**Consultation Response from KC,
Trees**

2025/91579 The Homestead, Hurst Knowle, Almondbury, Huddersfield, HD5 8SG

Demolition of the former Homestead care home and erection of 28 dwellings, comprising 20 apartments and 8 bungalows, with access from Hurt Knowle and associated external works including landscaping

Date Responded: 08/08/2025

Appendix 4:
Tree Protection Plan
The Homestead, Hurst Knowle, Almondbury
Ref: AWA6641AMS
BRITISH STANDARD 5837:2012
SCALE: 1:500 PAPER: A2

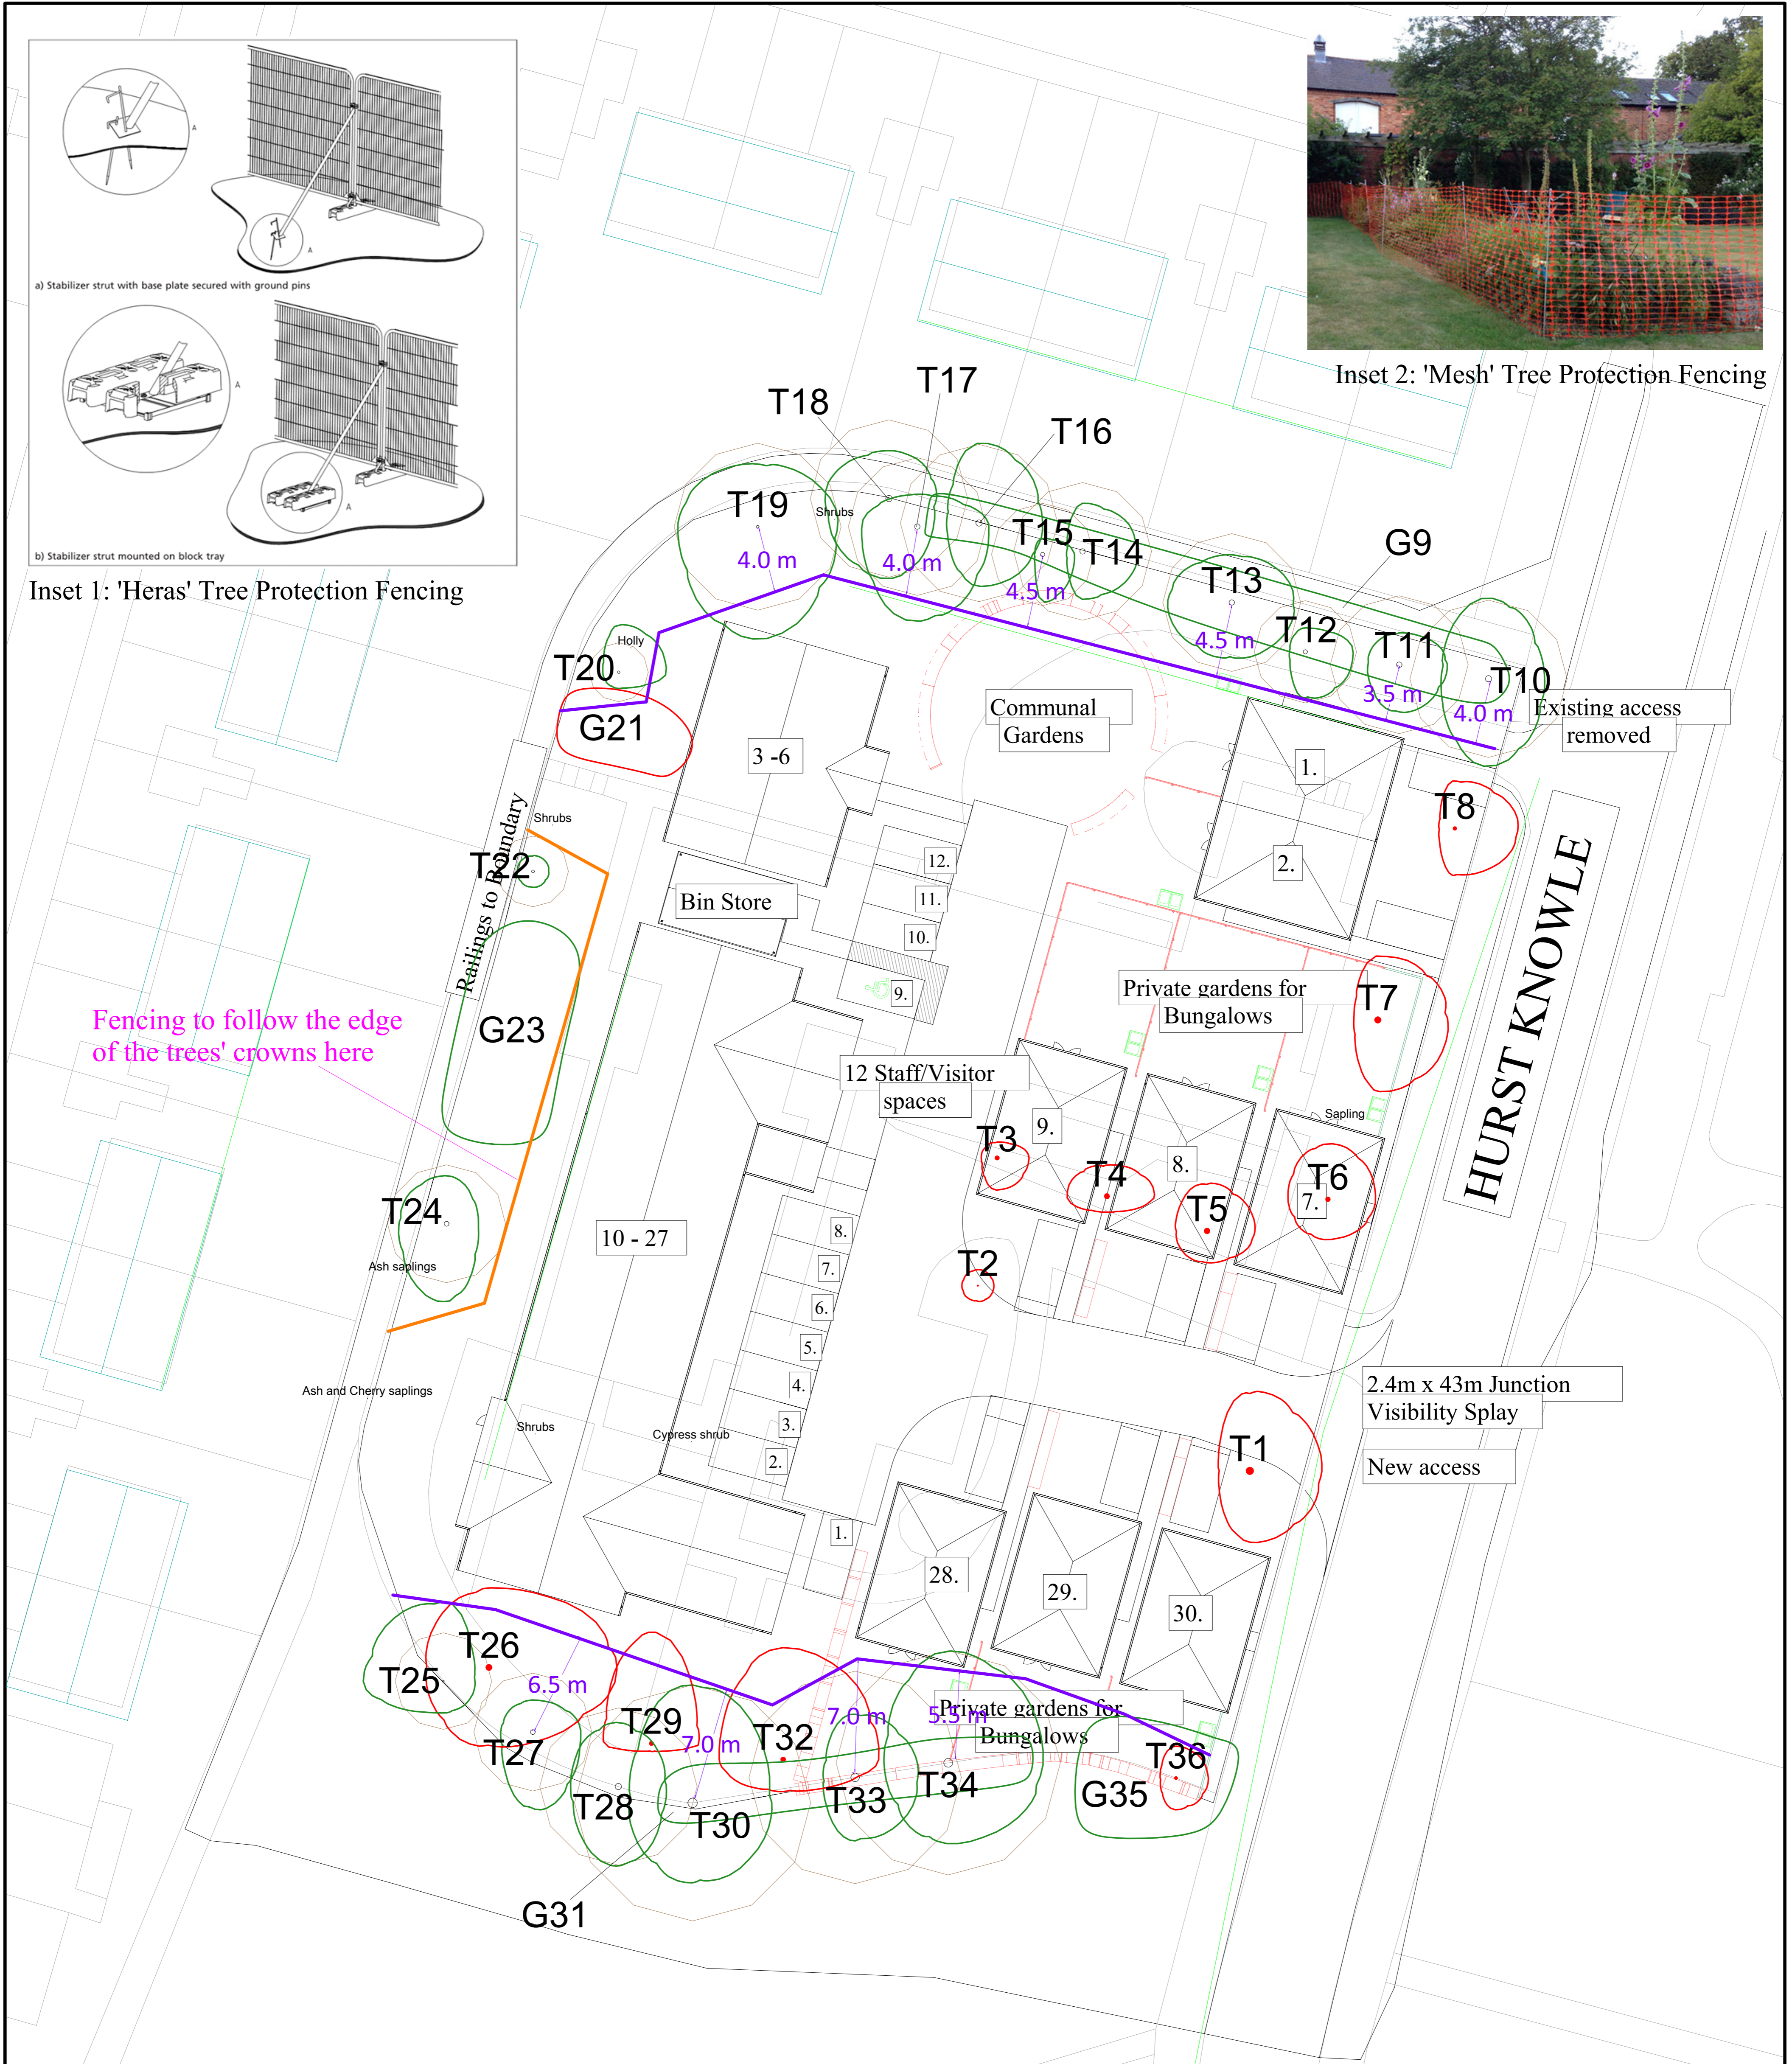
The majority of the proposals seem achievable and the removal of T1-T8 and G21 are acceptable losses that can be mitigated with replacement planting; however, no landscape plan has been submitted that suggest these trees will be mitigated.

There are concerns that plots 28, 29 and 30 are situated to close to trees T33, T34 and G35. Due to these plots being situated to the north and within such close proximity of these trees it is highly likely that they will be cast in shade for the majority of the day and as the canopies grow they will eventually overhang these properties. This would lead to increased pressure to remove these category B trees.

There is a holding objection on the grounds that the above plots will result in further tree loss of category B trees. KC trees would reconsider its position if an alternative design is submitted showing less impact to these trees.
